**WELWYN HATFIELD COUNCIL – DEVELOPMENT CONTROL**  
**DELEGATED REPORT**

<b>APPLICATION No:</b>	<b>S6/2010/1371/FP</b>
------------------------	------------------------

The proposed development would involve a single storey rear extension, hip-to-gable roof alteration and a rear dormer window.

FRONT ELEVATION. (proposed)

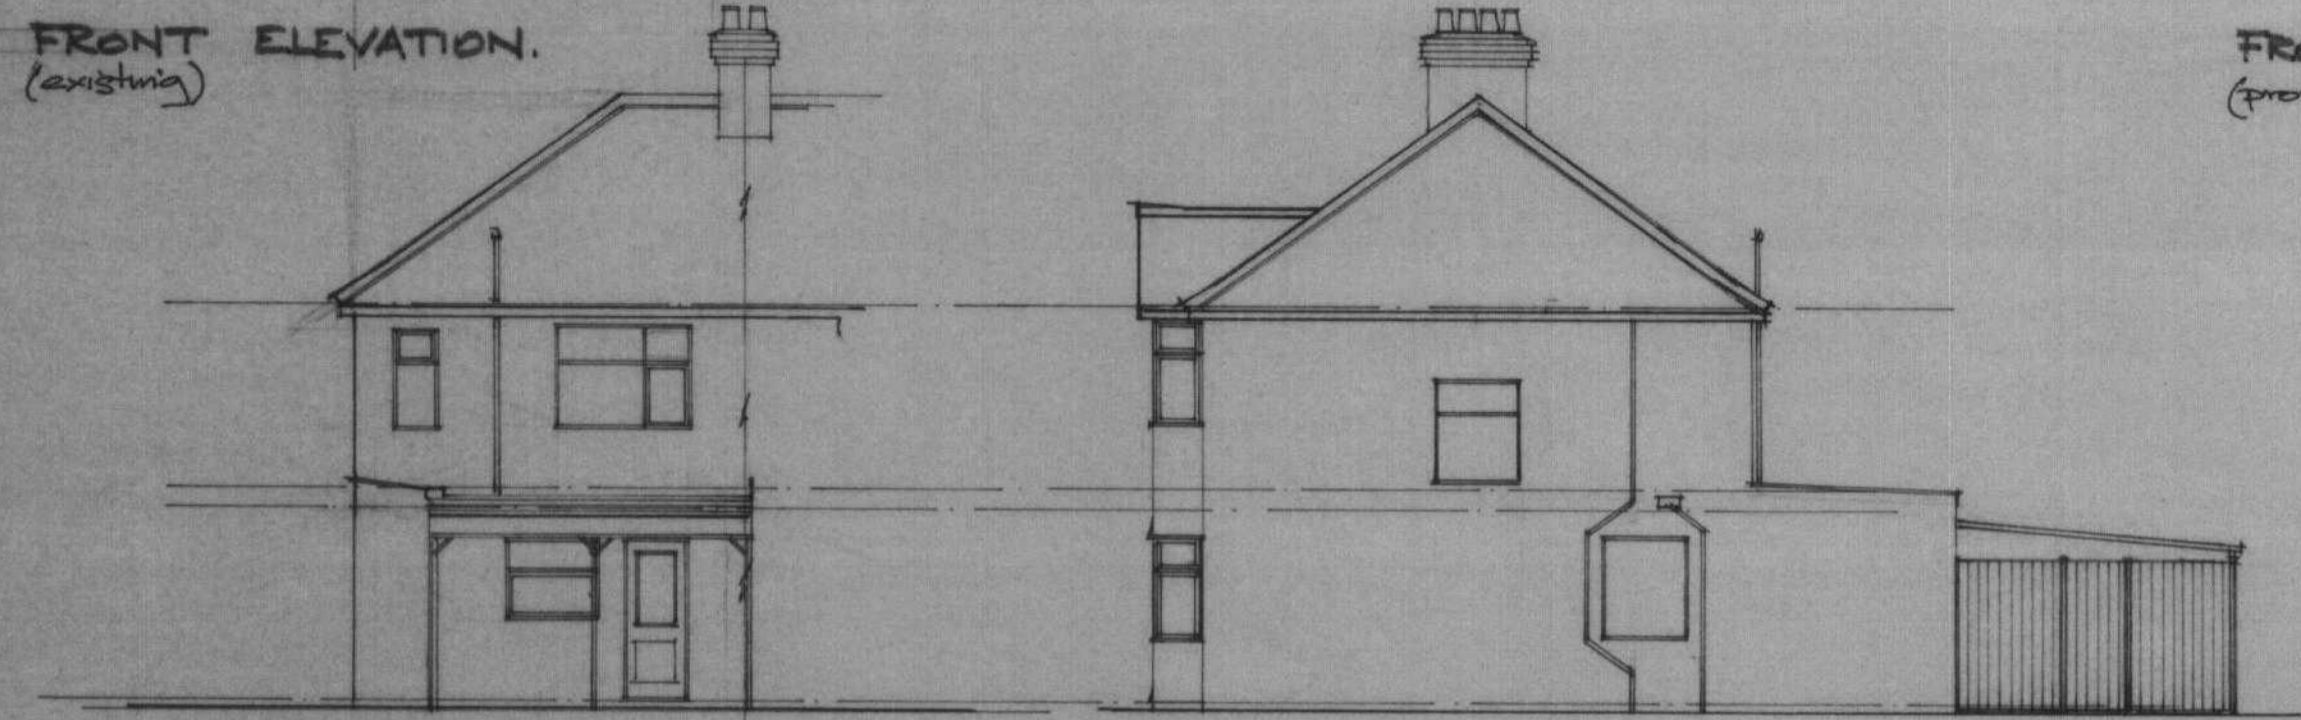
The Town Council have just given the one objection to this application. The rooflight on the second floor at the front of the property. The Council consider the rooflight out of keeping with neighbouring properties and therefore inappropriate.

The plans were subsequently amended to remove the rooflight.
